TECHNICAL NOTE

PROJECT: Land west of Pagham Road – Approval of Reserved Matters (planning references: P/155/21/RES and P/158/21/RES)

REPORT: 2152/TN/03 – Response to highway officer consultation dated 30th November 2021

DATE: December 2021

TITLE:
SPINE ROAD AND
LOCAL CENTRE ACCESS

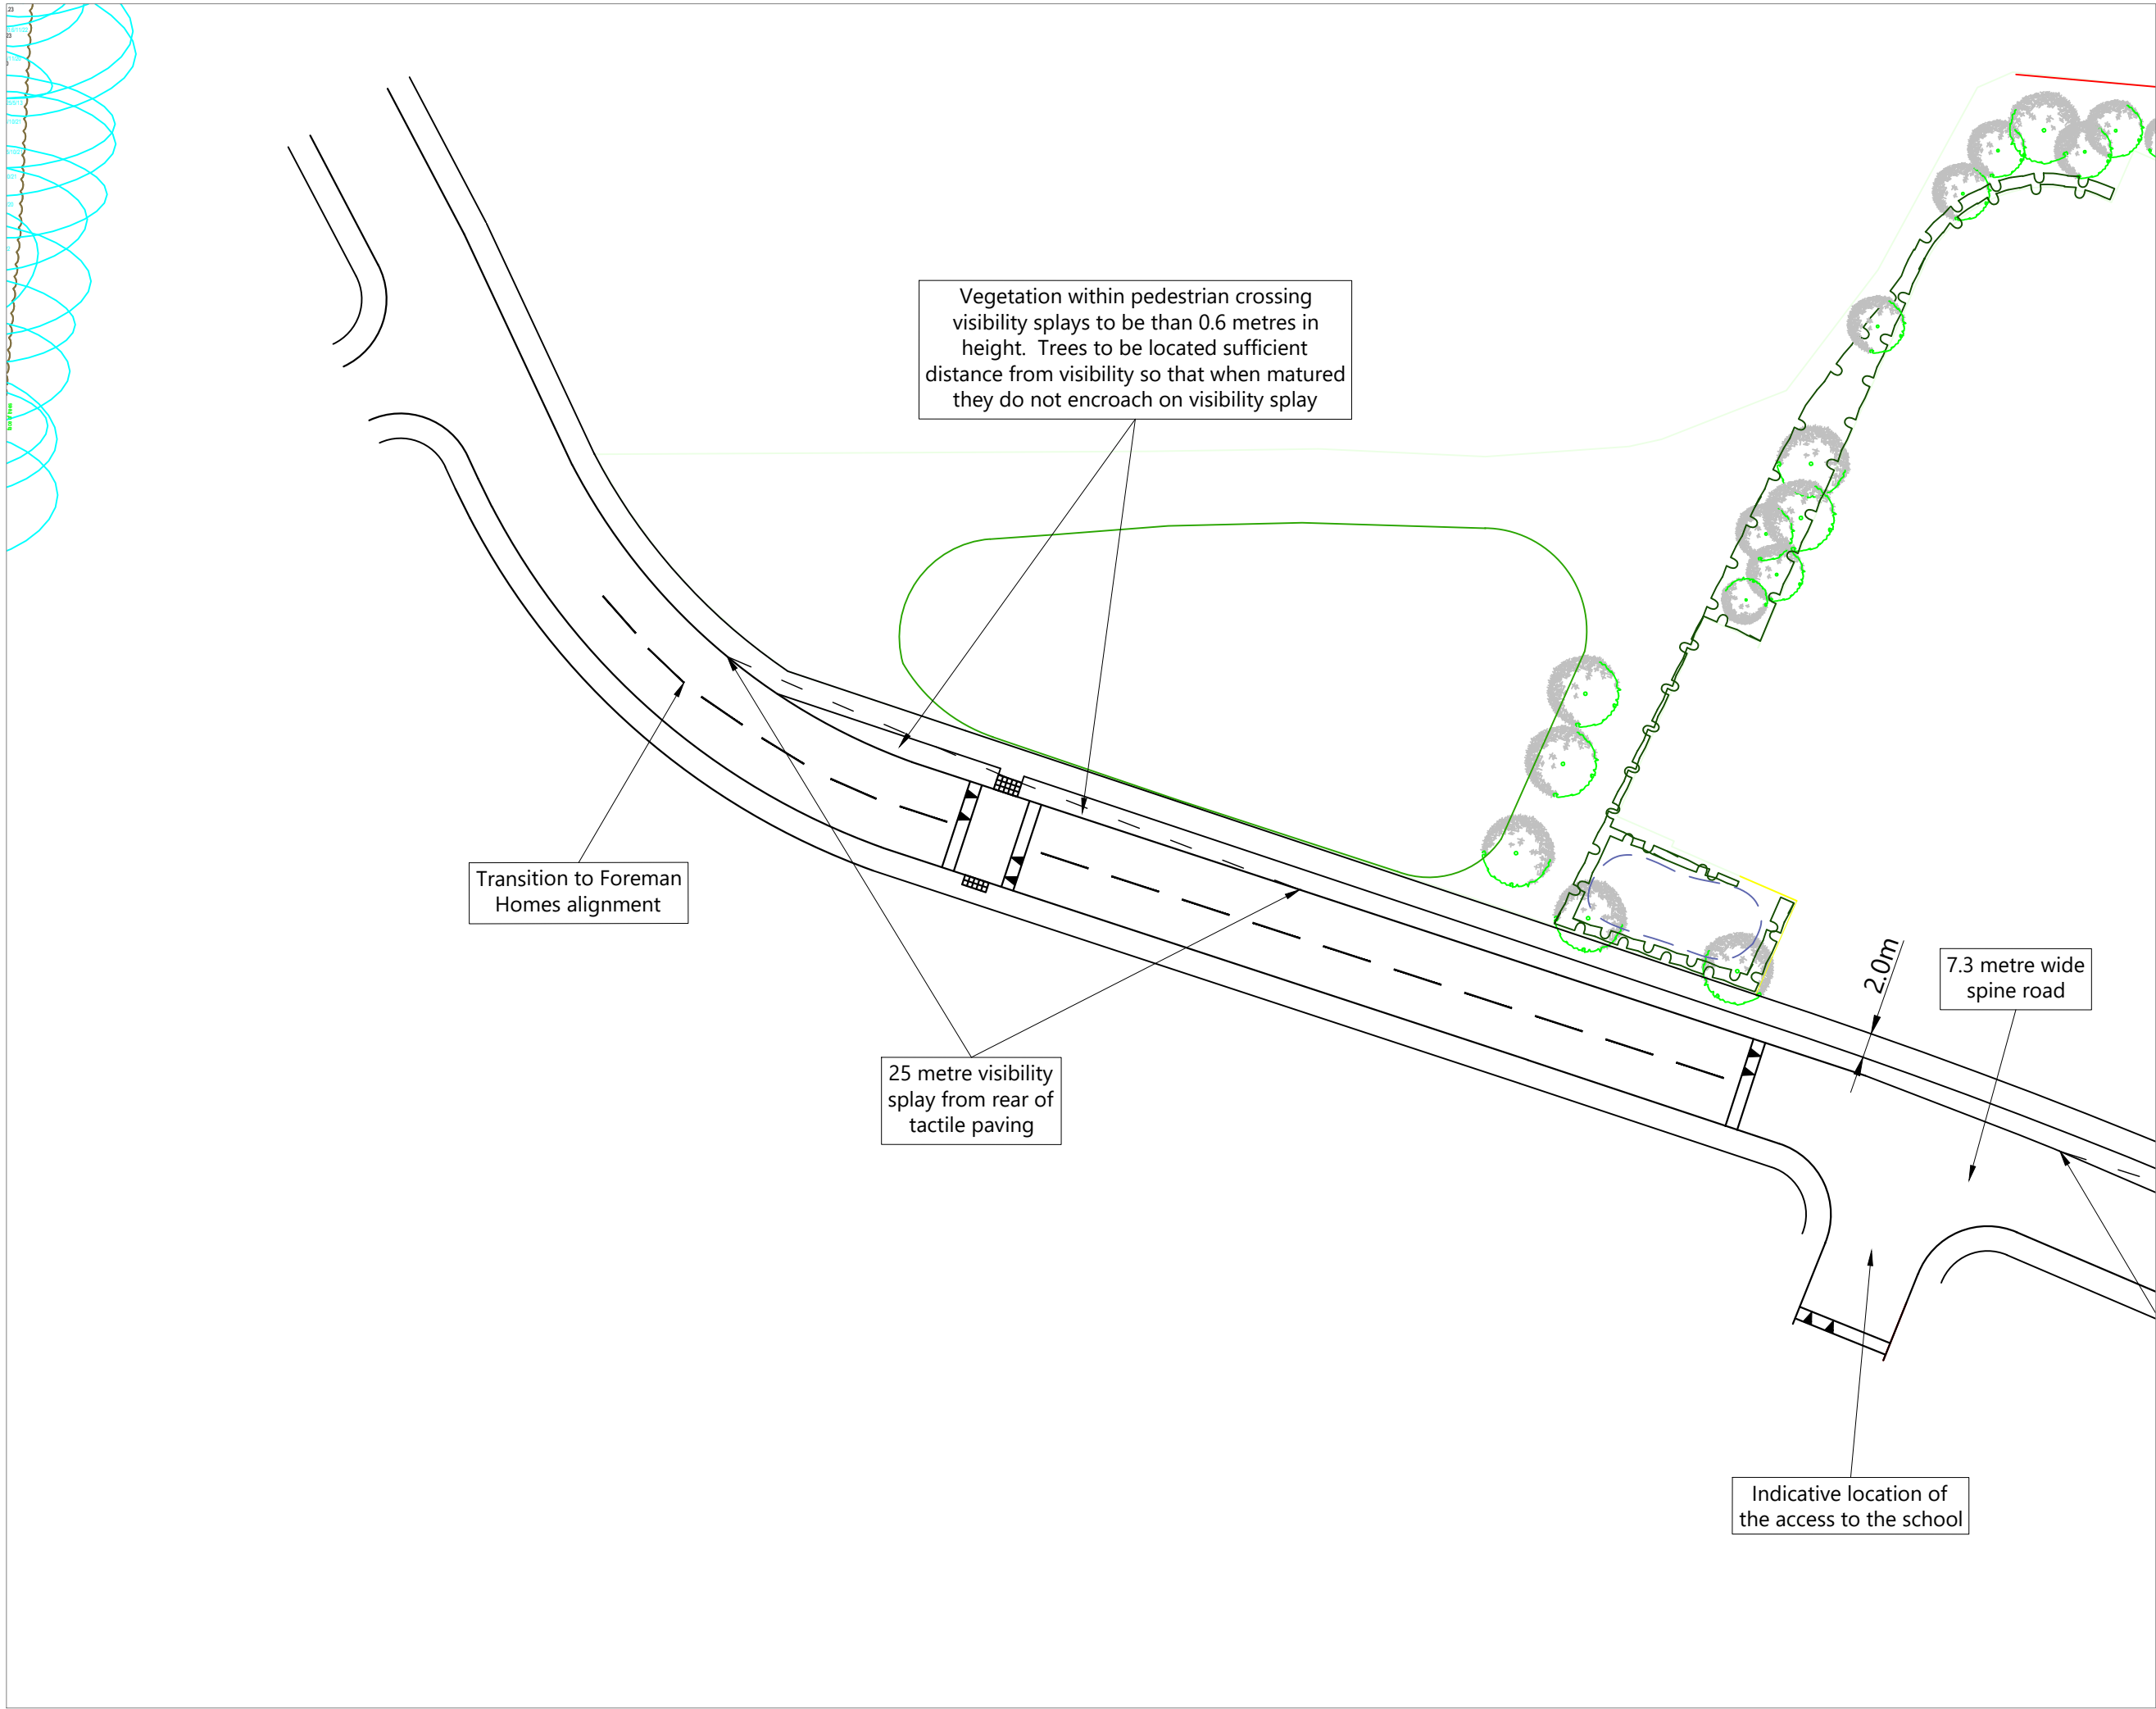
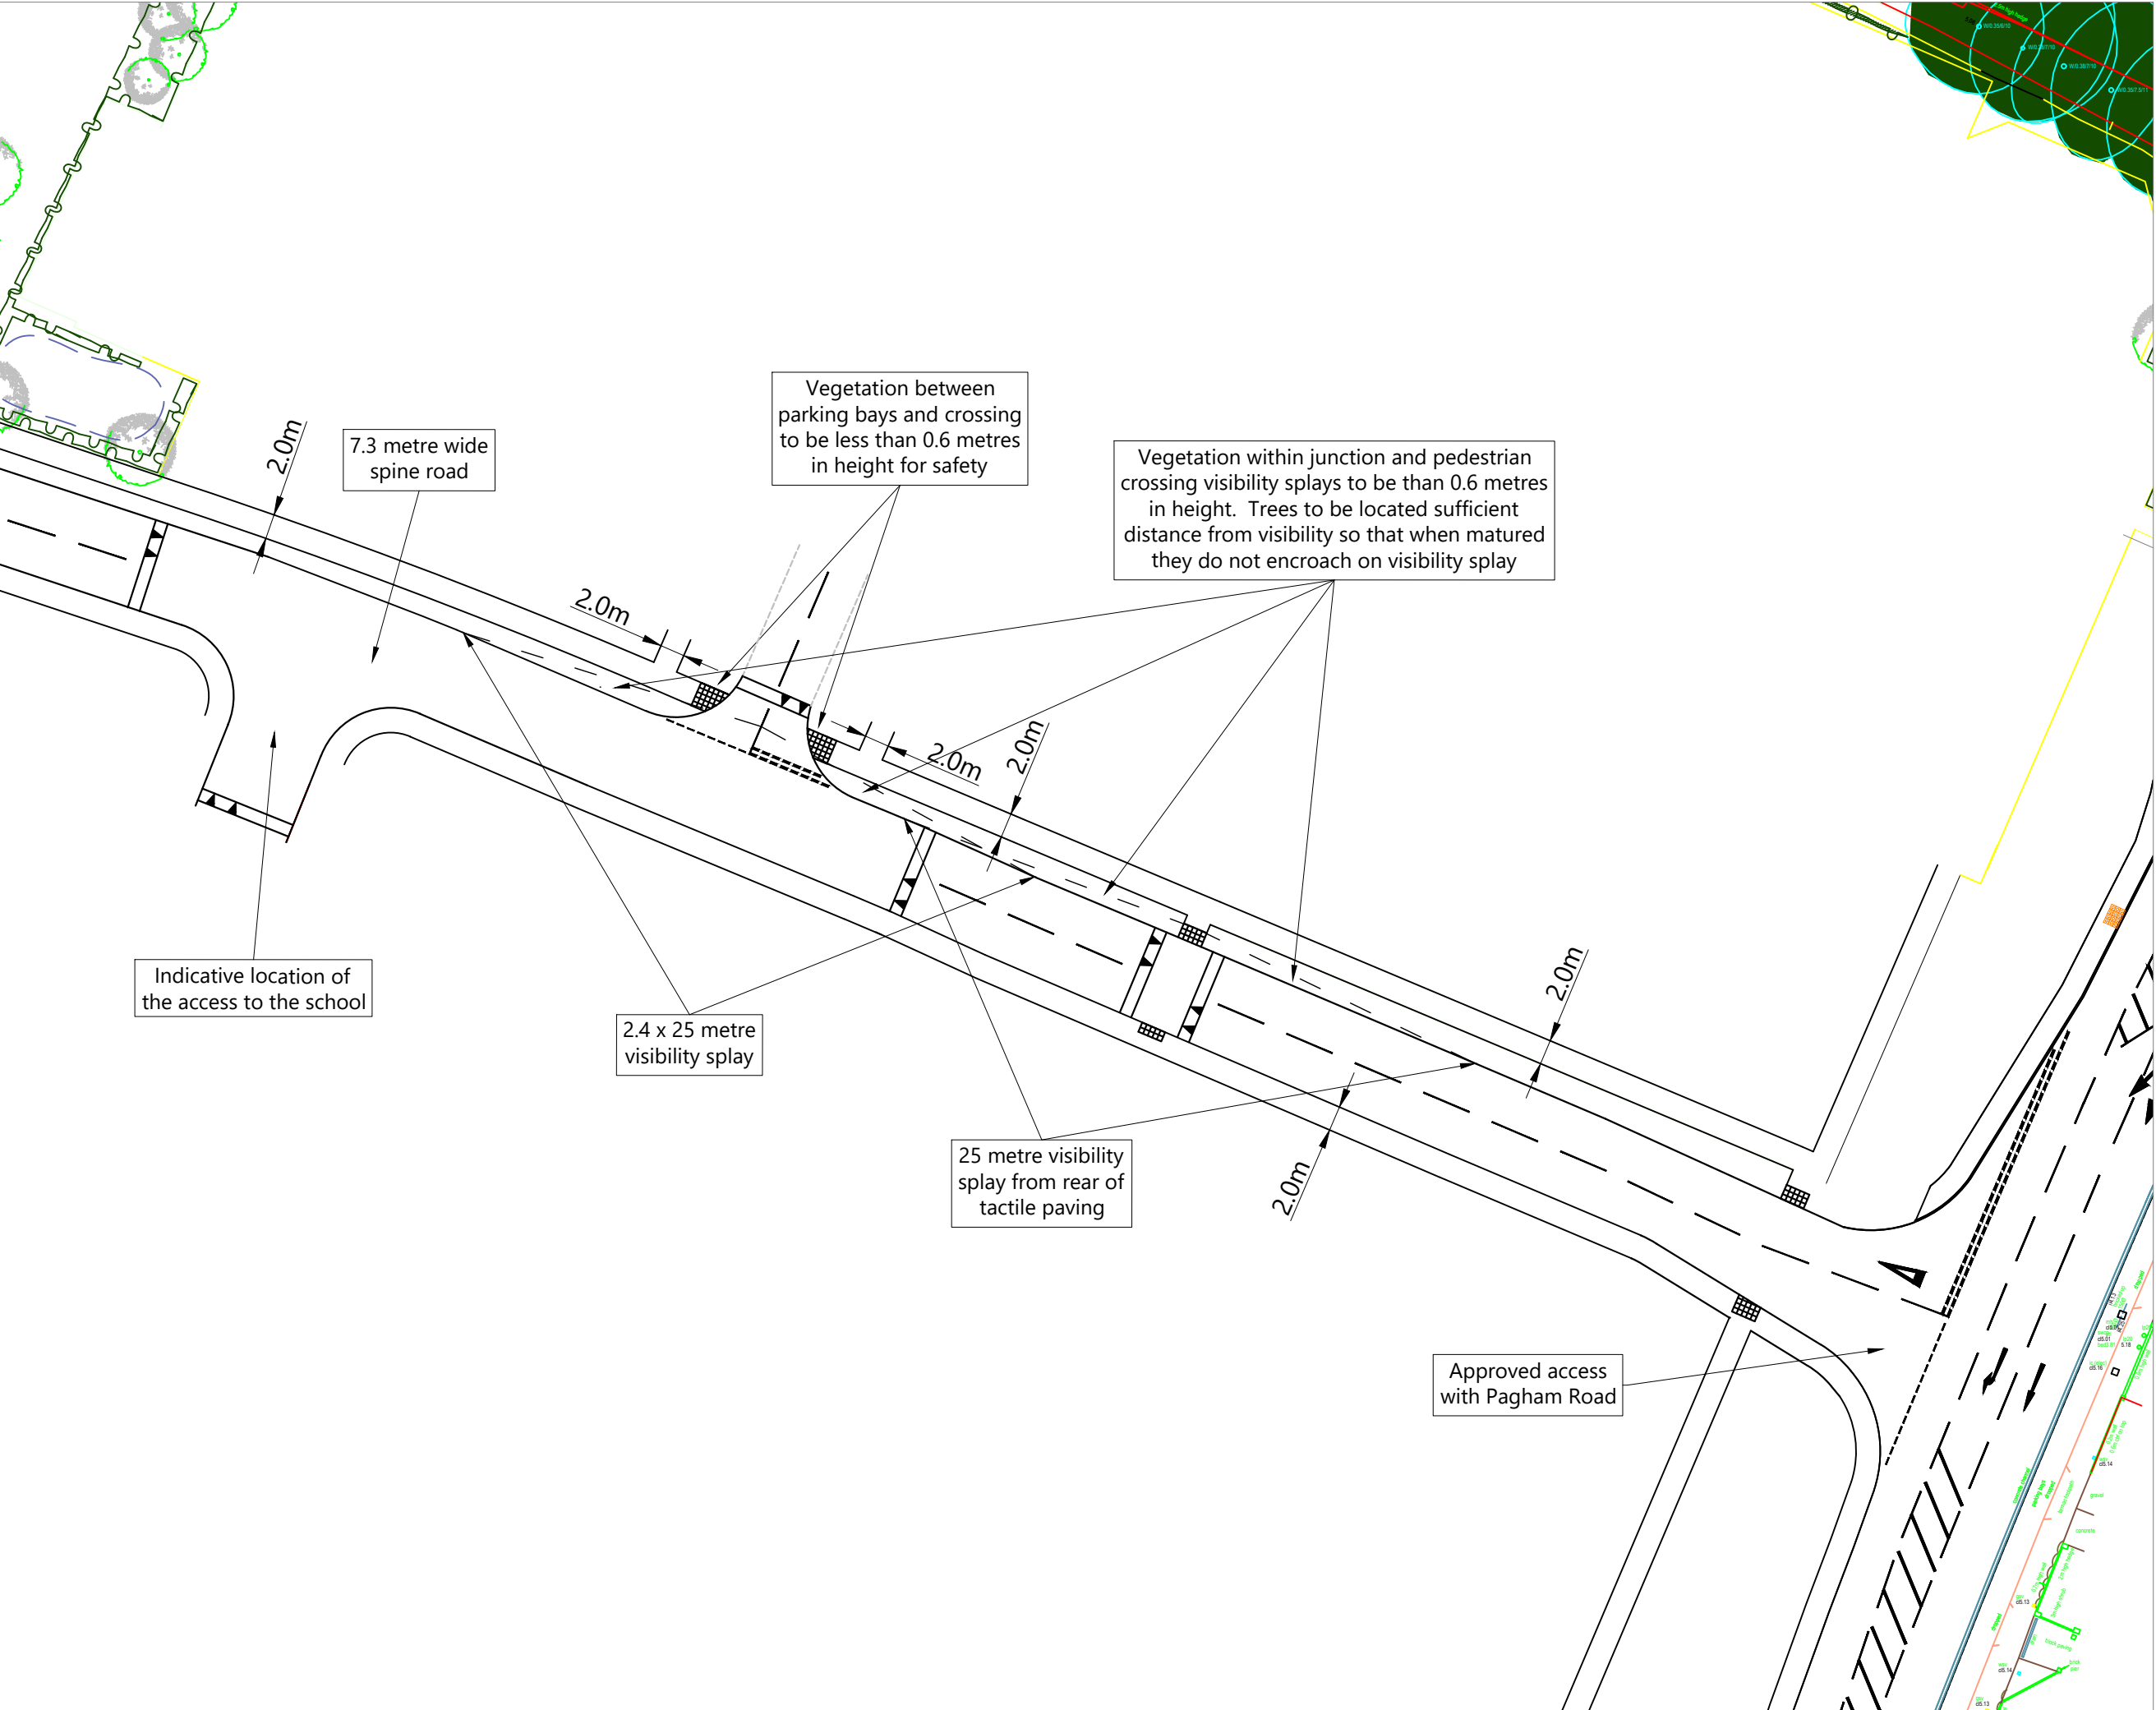
- i. A Stage 1 Road Safety Audit should be submitted due to the presence of the future school.
 - ii. Along the frontage of the local centre and school the spine road is shown with a width of 7.3 metres, further justification of this width should be provided to show that it is compatible with the 20mph speed restriction proposed.

In terms of more detailed matters, WSCC Highways have previously questioned the need for the 7.3 metre wide road across the school frontage; this road width is considered at odds with the 20mph design speed proposed. This aside, very limited consideration appears to have been given particularly to the potential demands arising from the school site (i.e. parent parking, dwell space/footway widths along the frontage) or the need for school safety zone type features (e.g. enforceable restrictions (i.e. 'School Keep Clear and No Waiting At Any Time (which may need to be wrapped around onto Pagham Road also). The applicants for P/153/21 and the current application will need to incorporate such elements into the design.

11. Swept path analysis for an 11.0 metre refuse collection vehicle was provided within the Transport Statement that supports the application and is provided at **Appendix 2** for ease of reference. From this it can be seen that the road width is required to serve the local centre via the proposed access. It also likely that a similar road width would be required, in any event, for school buses/coaches (including those required for school trips).
12. The 7.3 metre road width is proposed to ensure that large vehicles are able to conveniently and safely serve the local centre and school sites. Speed tables form part of the spine road design to ensure compatibility with the 20mph speed restriction. The S278 approval for the spine road/Pagham Road junction confirms the spine road width to be 7.3 metres.

- ii. The 7.3 metre wide access road has been provided to ensure access to the local centre and school by large vehicles is safe and convenient.
 - iii. The details of drop off/collection arrangements, double yellow lines and school keep marking will be for consideration as part of the future planning application for primary school.
